## City of Ryde Submission to the Independent Auditor for Meadowbank Education and Employment Precinct Schools Project (SSD 9343)

Key compliance issues relating to post- approval requirements

Submission Date: 20 October 2021

Figure 8.1: Key pedestrian access routes

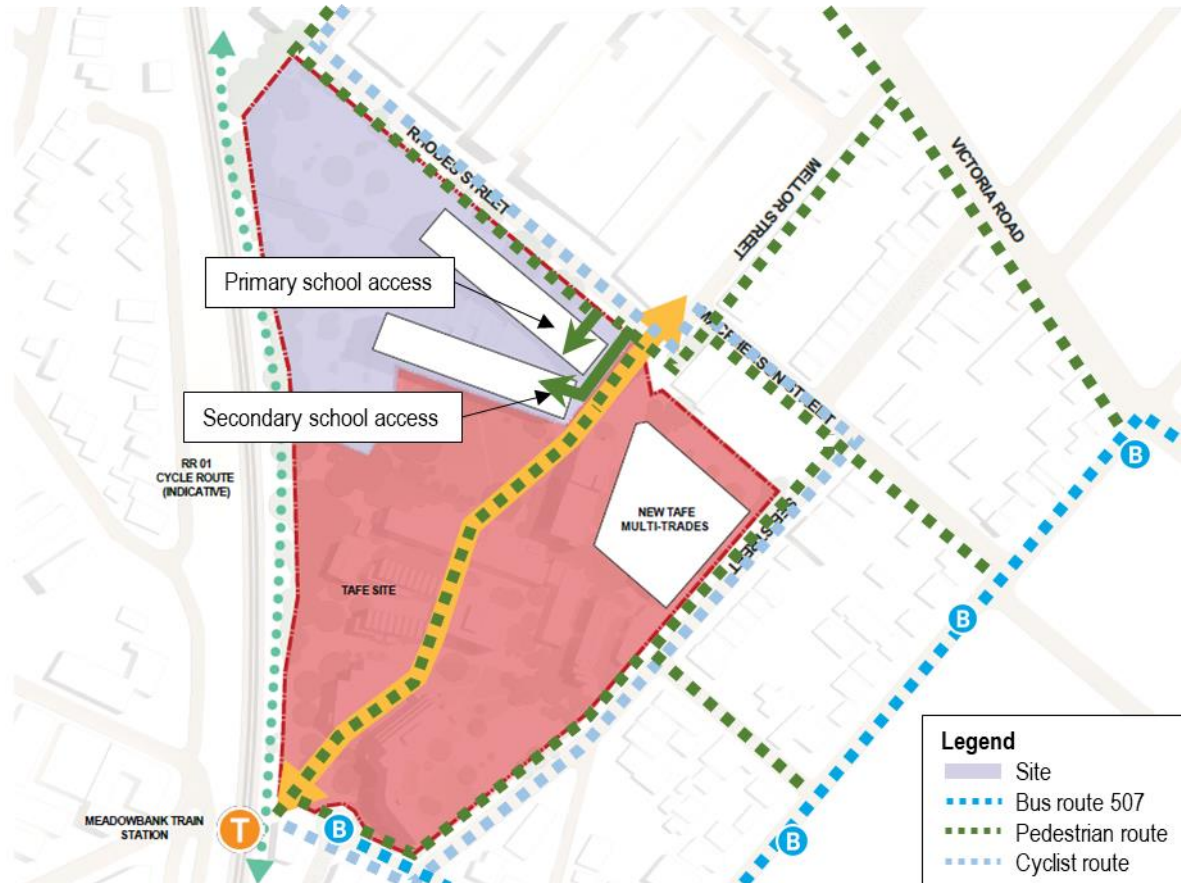
ITEM No.	Particulars under the SSD Consent SSD-9343	Compliance Requirements	Applicant's Response to date and possible issues
1	<b>Pedestrian Infrastructure Improvements - Condition B44(a):</b> This Condition requires a 2.5m wide shared use path along western side of Hermitage Rd.	<p>A Roads Act approval for the 2.5m wide shared user path (SUP) have been issued on 22/7/2021 under Conditions B44(a), D14 &amp; D15. This must be constructed in accordance with the approval.</p> <p>However, also important is the need for an additional 1.2m wide footpath on the western side of Hermitage road to provide a pathway for children being dropped off along the western side of Hermitage Road to walk to the site. This 1.2m wide footpath is required as the steep slope of the road verge is such that children being dropped off along the western side of Hermitage Road cannot access the elevated shared path. This requirement must be completed as per SMEEP-Public Domain Strategy Workshop and Council's public domain enhancement strategy consultation progress and documentation package agreement on 26/2/2021 and the Road Acts approval on 22/07/2021.</p> <p>(Photo below of the site condition)</p>	<p><b>Representatives have mentioned in at a meeting with Council staff on 29 September 2021 that they do not wish to provide the 2.5m shared user path.</b></p> <p><b>The applicant has also indicated that they may not be constructing the 1.2m wide footpath, which represents a non-compliance with the development consent.</b></p>

With regards to the non-compliances with the development consent identified above, the most critical is the applicant's intent to not proceed with providing a future pedestrian/cyclist connection to the site along the western side of Hermitage Road, which would be an adverse outcome for students, staff and visitors travelling to the school.

Part 8.2 of the *Transport and Accessibility Impact Assessment* report prepared by GTA Consultants (now called Stantec) dated 14 October 2019, for which the works outlined in the development consent is based on, has specifically recommended for the "*continuation of the existing Hermitage Road shared path from the Sydney Water driveway to the Rhodes Street site access*" as a key measure to support and encourage greater walk and cycle trips to the site, which is essential considering the approved development provides a lack of car parking spaces on site. (Around 60 parking spaces is proposed to be provided on site for 2,620 students and 215 staff. This is well below Council's DCP requirements).

Figure 26 | Location of Department's recommended pedestrian infrastructure upgrades (Base source: Nearmap)

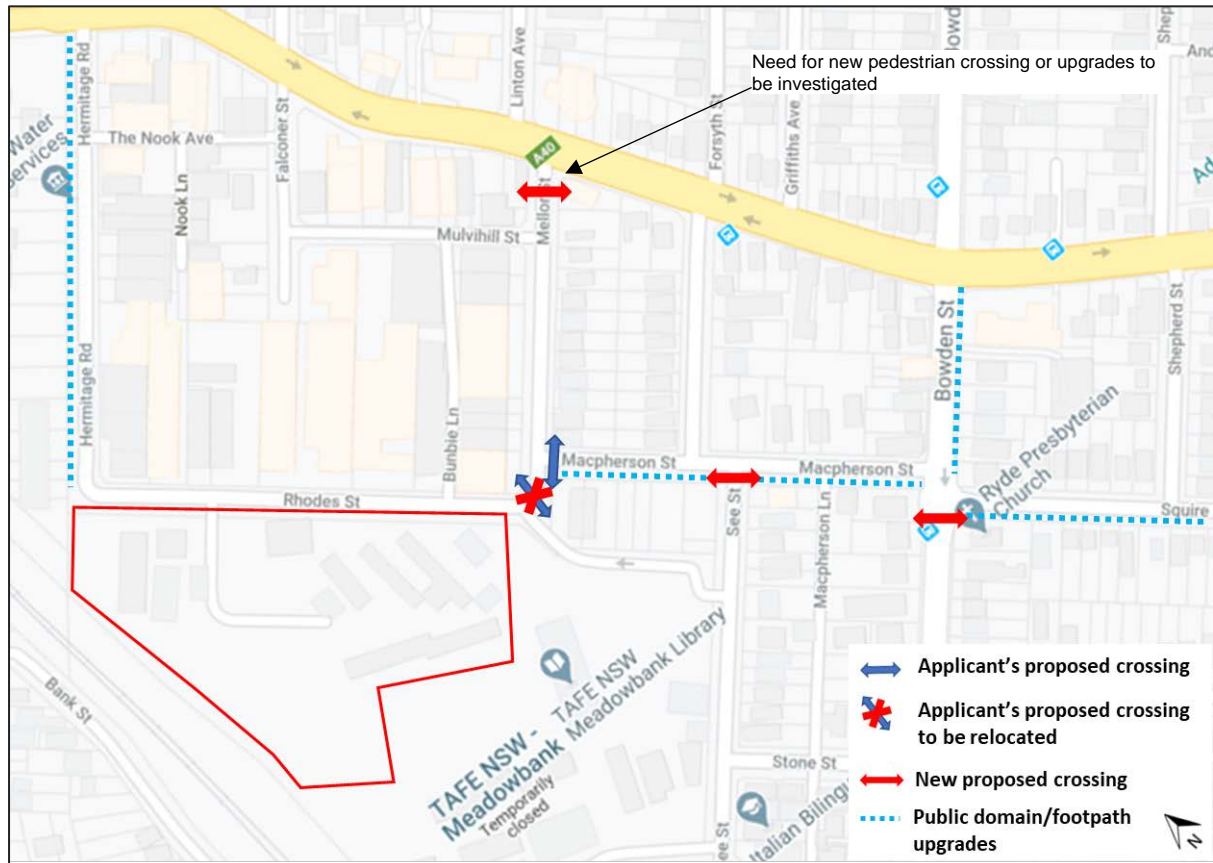
9	Prior to the commencement of the operation of the new schools, the Applicant must consult with Council and TfNSW in relation to the need for the provision of a wombat pedestrian crossing or alternative pedestrian infrastructure upgrade works at the northern end of Mellor Street near/at its intersection with Victoria Road. (Condition D10)	This is required.	<b>The applicant has previously indicated that they will not deliver on this work.</b>

With regards to the other non-compliances, it is noted that the applicant has recently submitted a School Travel Plan to address Condition D17 of the development consent, whereby the plan indicates that a significant number of students and staff travelling to the site by walking and/or cycling will originate from the south and east of the school site. As such, the pedestrian and cyclist infrastructure commitments (required in accordance with the development consent), which the applicant is proposing to not provide can also affect the safety and efficiency in which students and staff can walk and cycle to the site from the south and east (in particular the pedestrian crossing across See St at Macpherson St).
